LSC Responses to PCD Engineering Division Traffic Impact Study Redlines

Copper Chase at Sterling Ranch Traffic Technical Memorandum (LSC #184990) December 14, 2021

PUDSP-22-002

Figure 4
Sight Distance

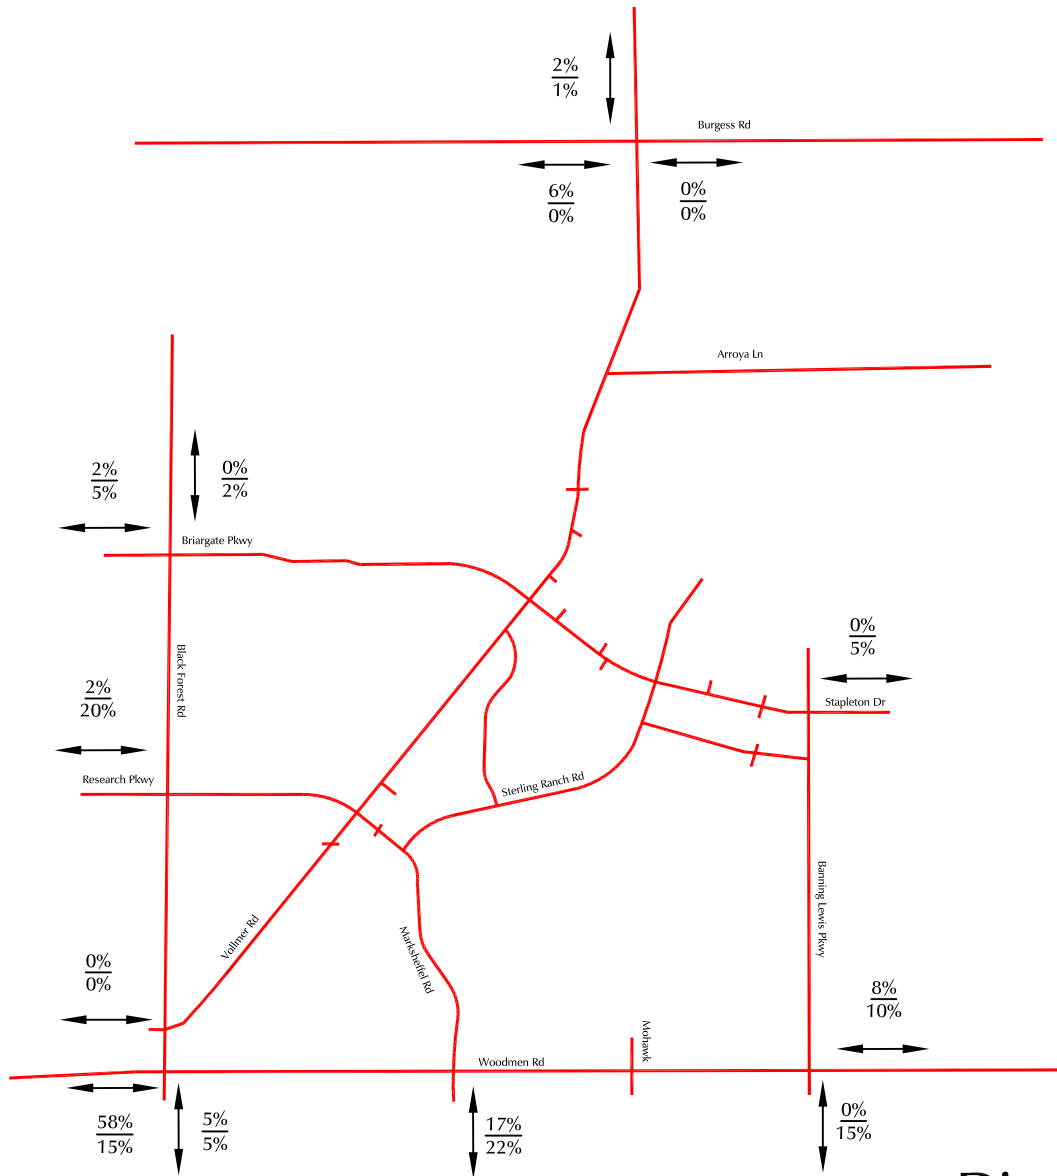
[Include discussion of sight distance evaluations, including intersection & stopping distances.](#)

LSC Response: Sight-distance analysis has been added to the updated memo as requested.

Figures 1-2

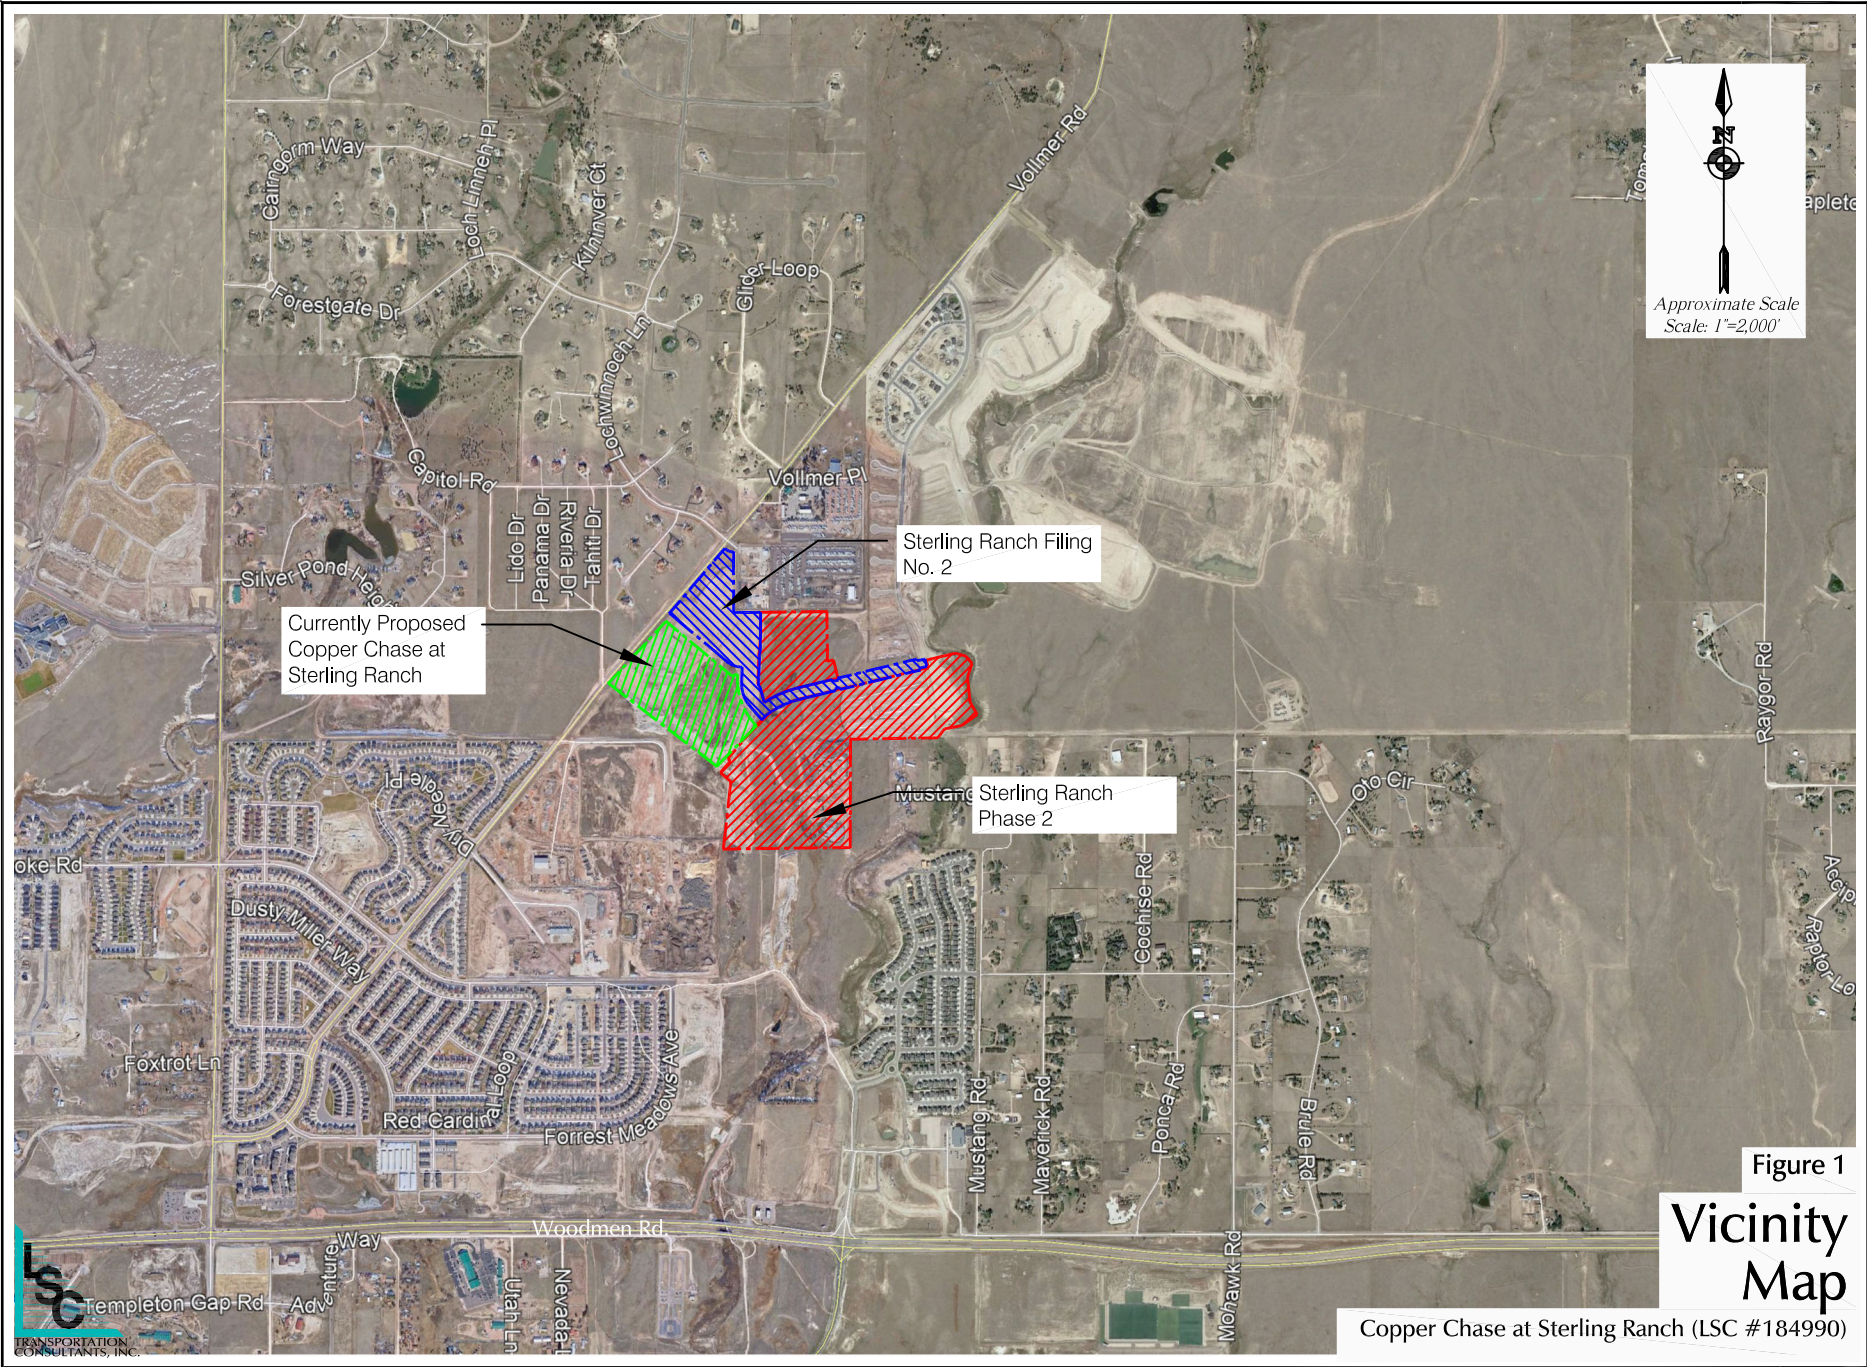
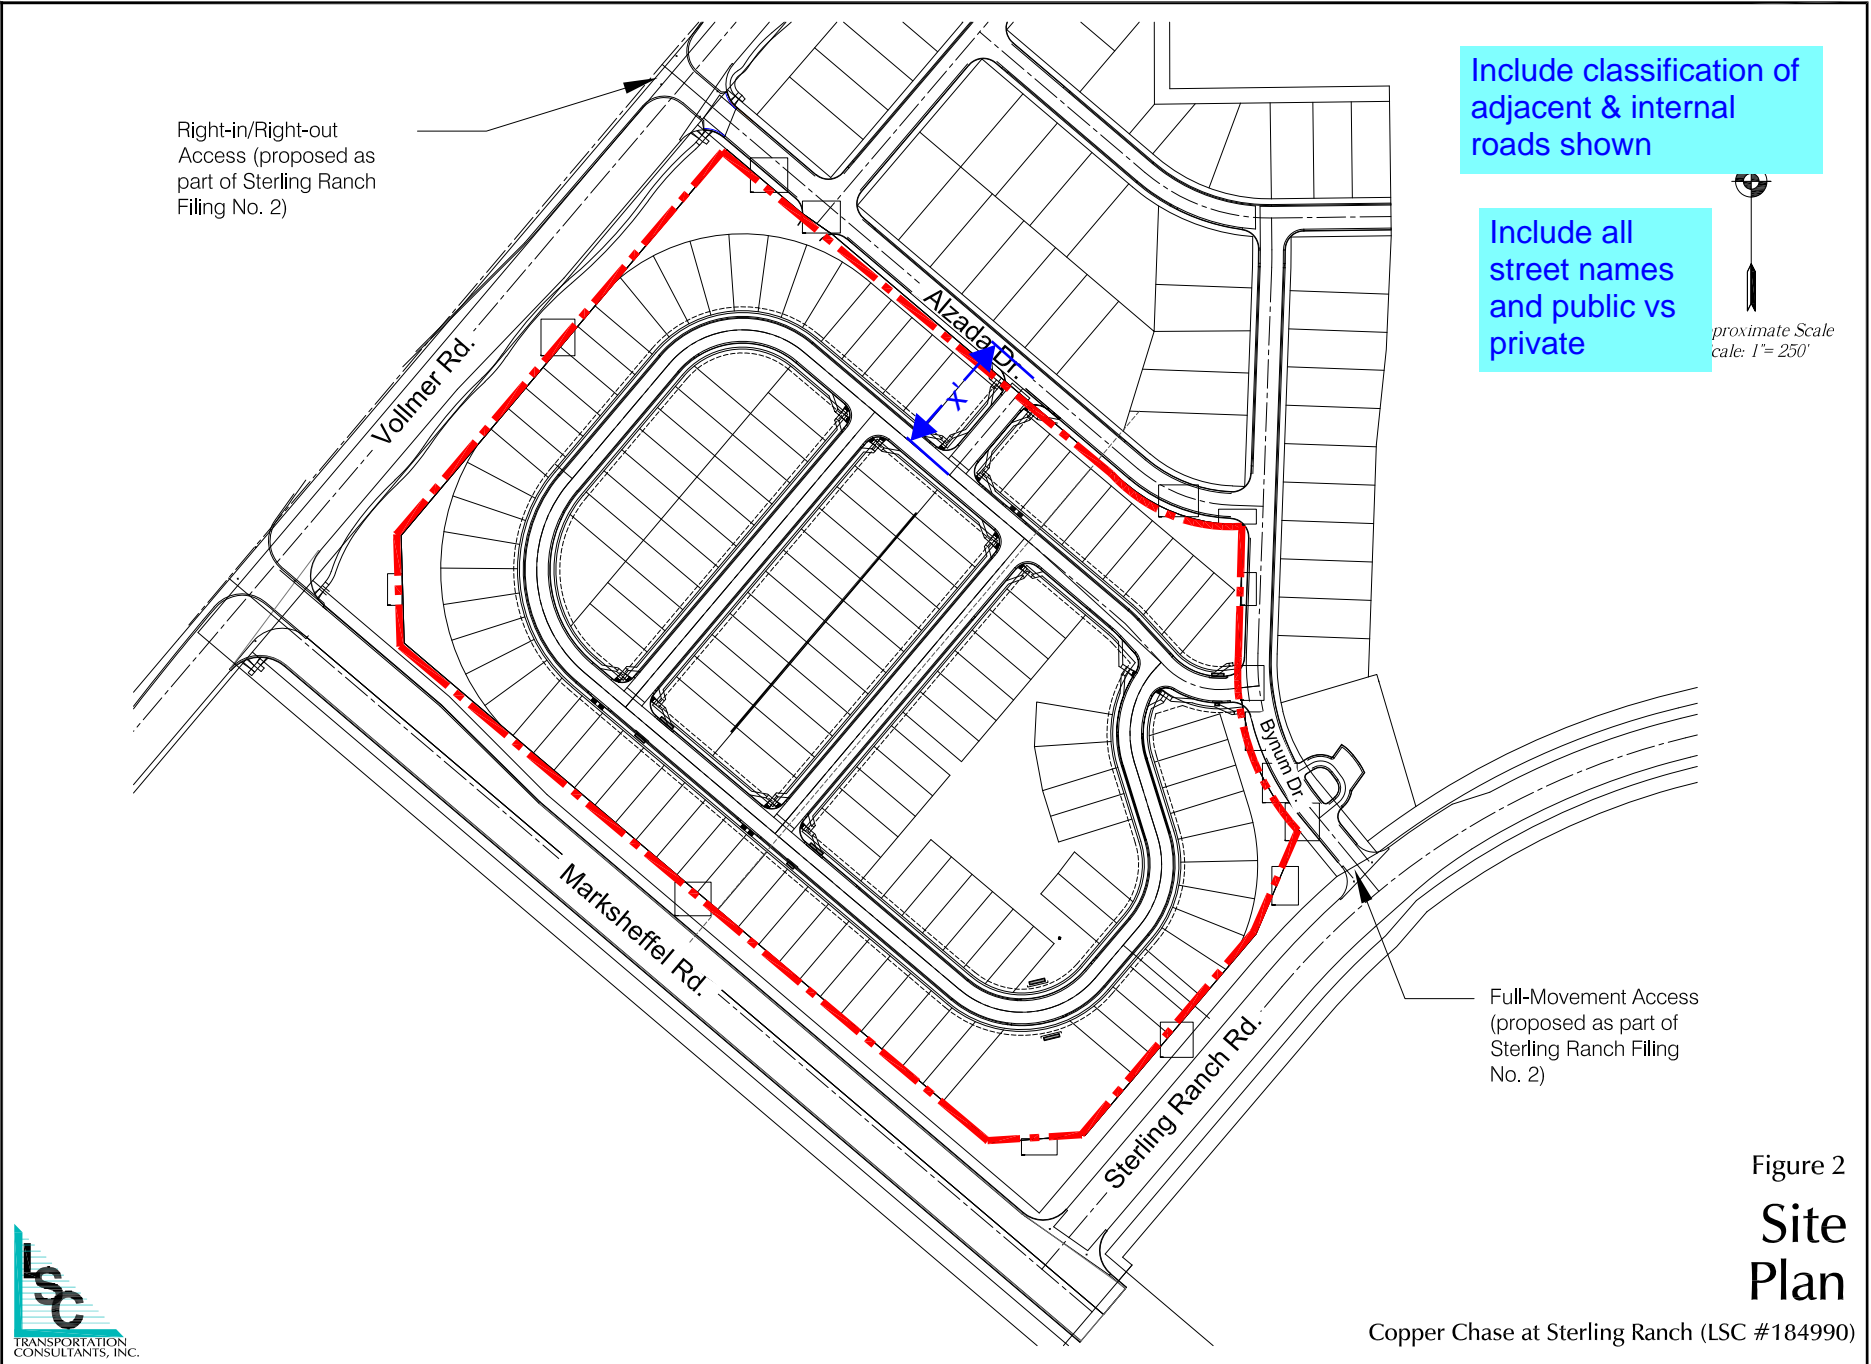
Include school pedestrian plan ¹

[Include school pedestrian plan](#)

[Include classification of adjacent & internal roads shown](#)

[Include all street names and public vs private](#)

LSC Response: Added as requested.

LSC Response: A classification figure has been added as requested.

LSC Response: The requested information has been added to the figure.
